Planning Application No: 3/2023/0546

Proposal: Demolition of existing single-storey side and rear extensions, and construction of two storey extension to the side and single-storey extension to the rear.

Location: 65 Mitton Road Whalley BB7 9RY

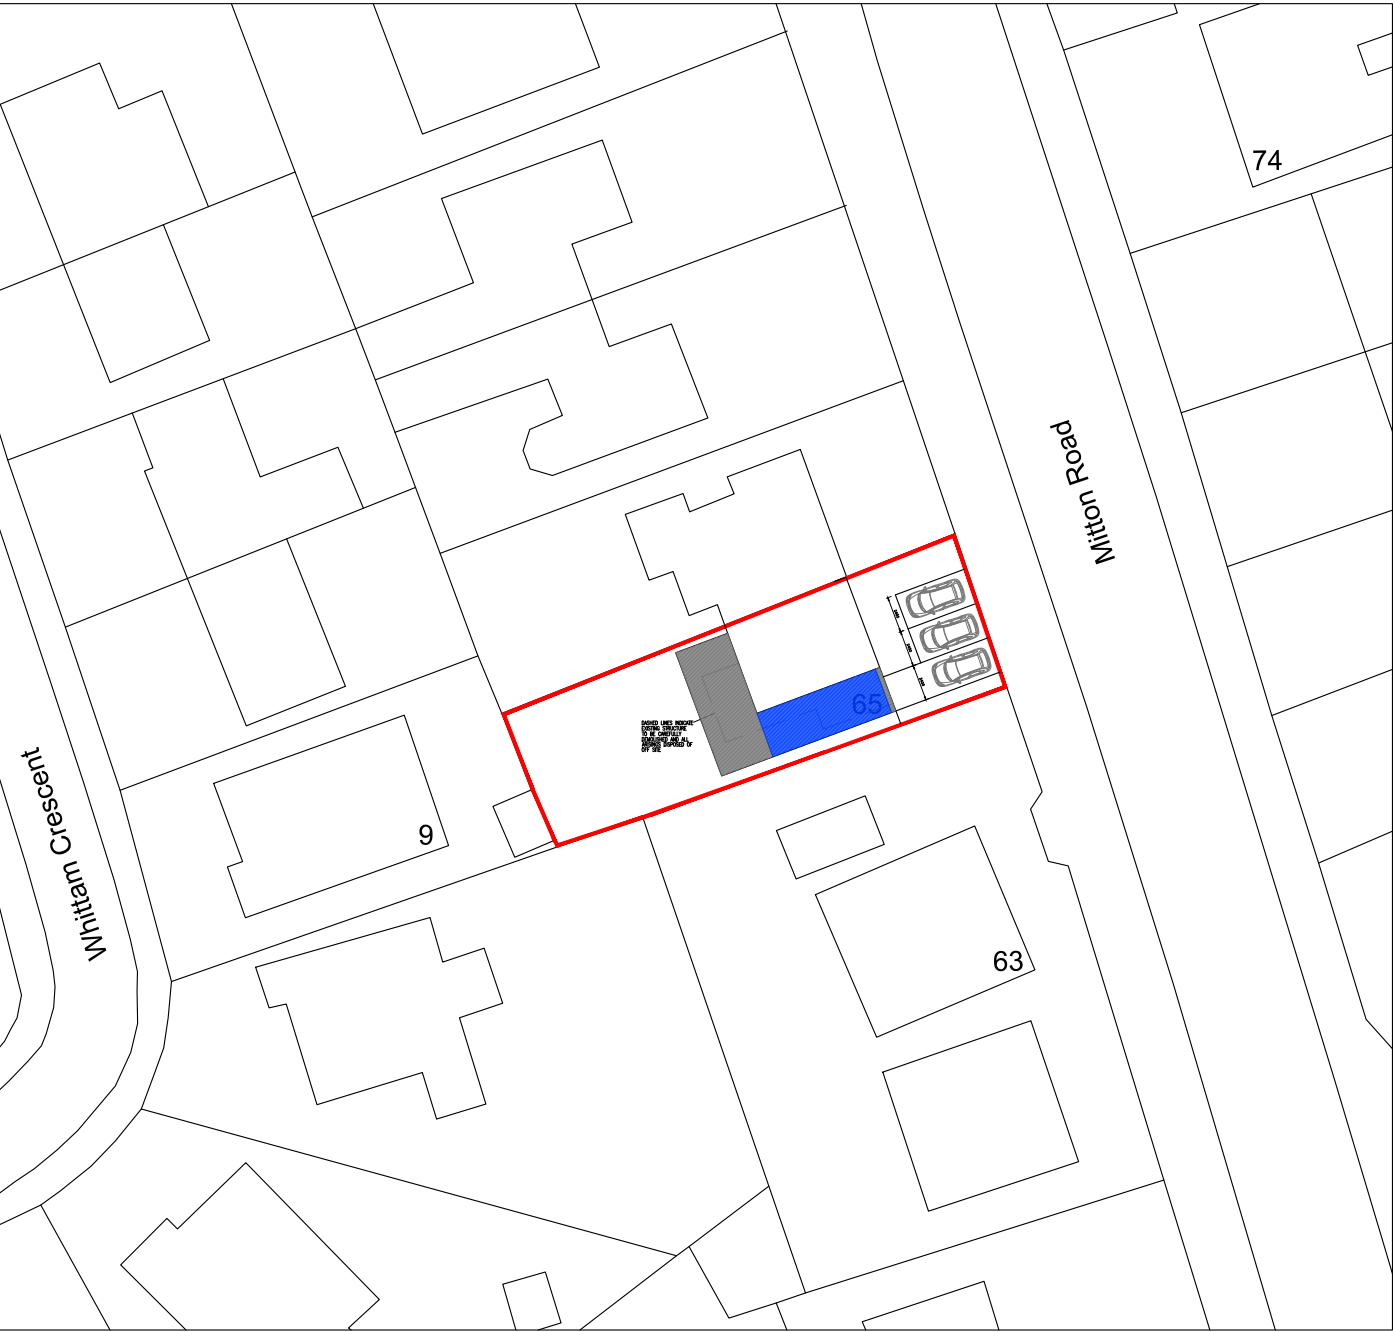
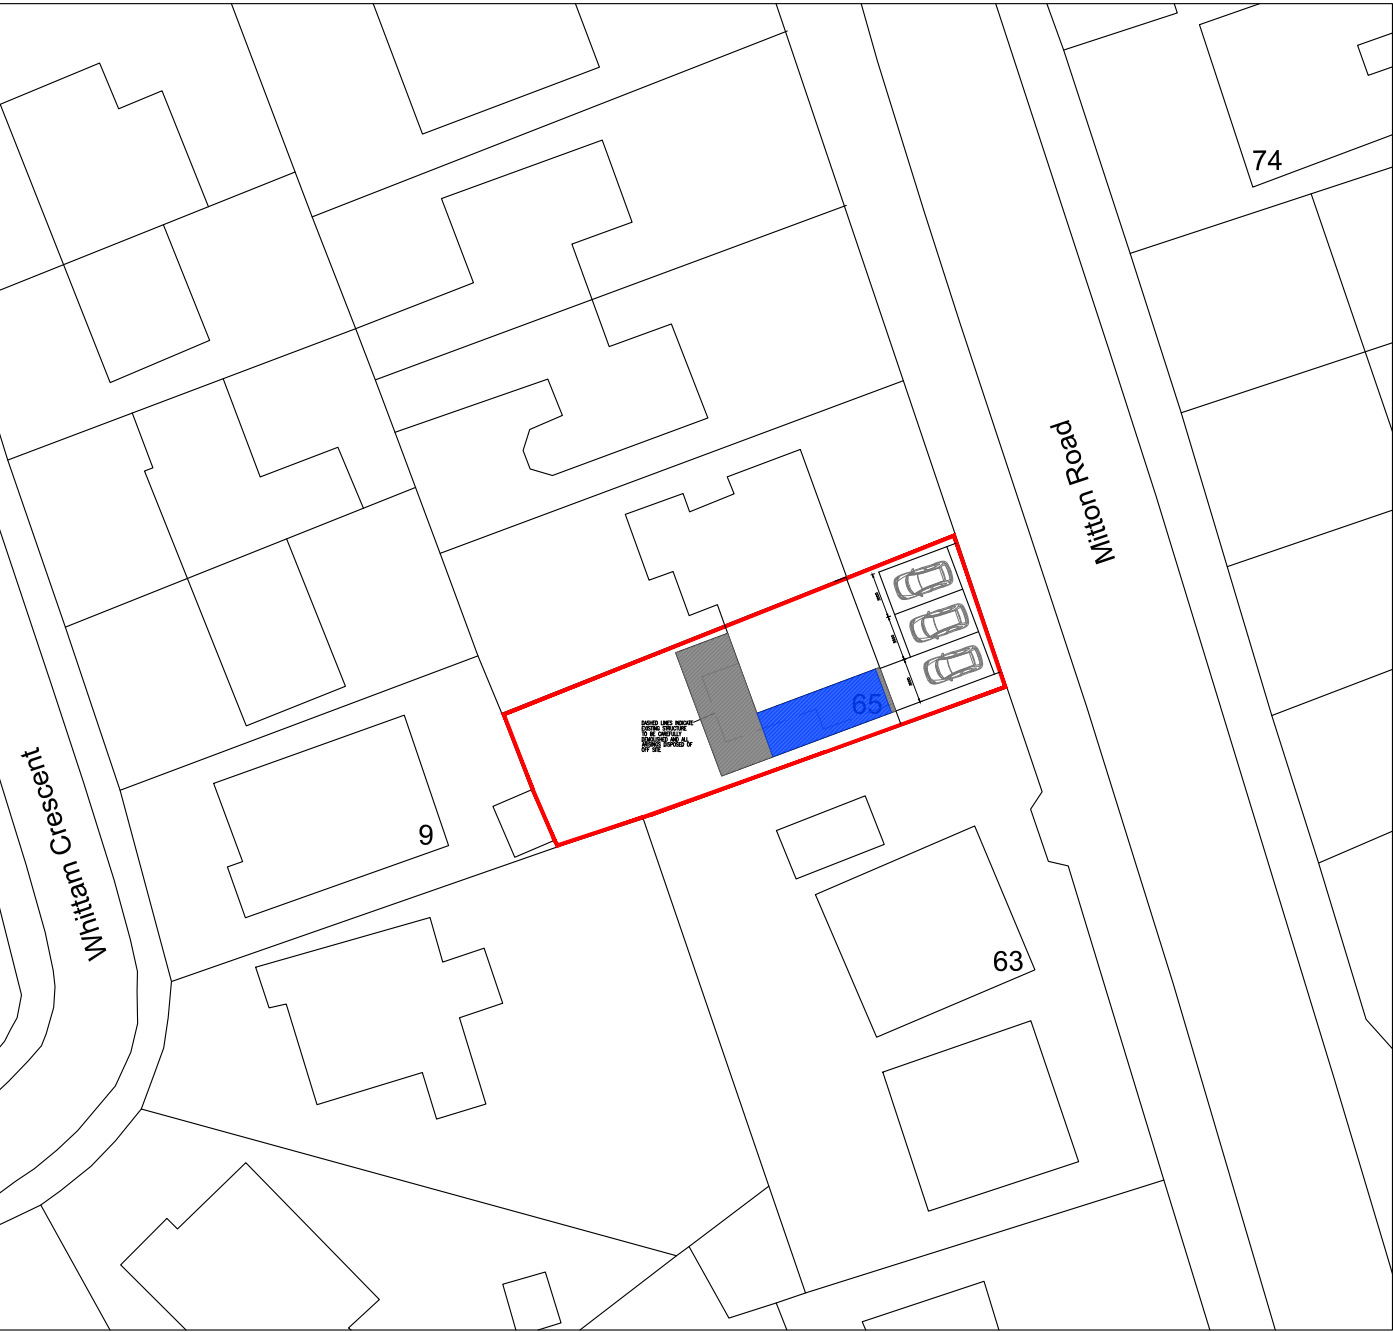
Whalley Parish Council would like to express concerns over changes to residential properties, resulting in insufficiency of, or reduction in off-street parking.
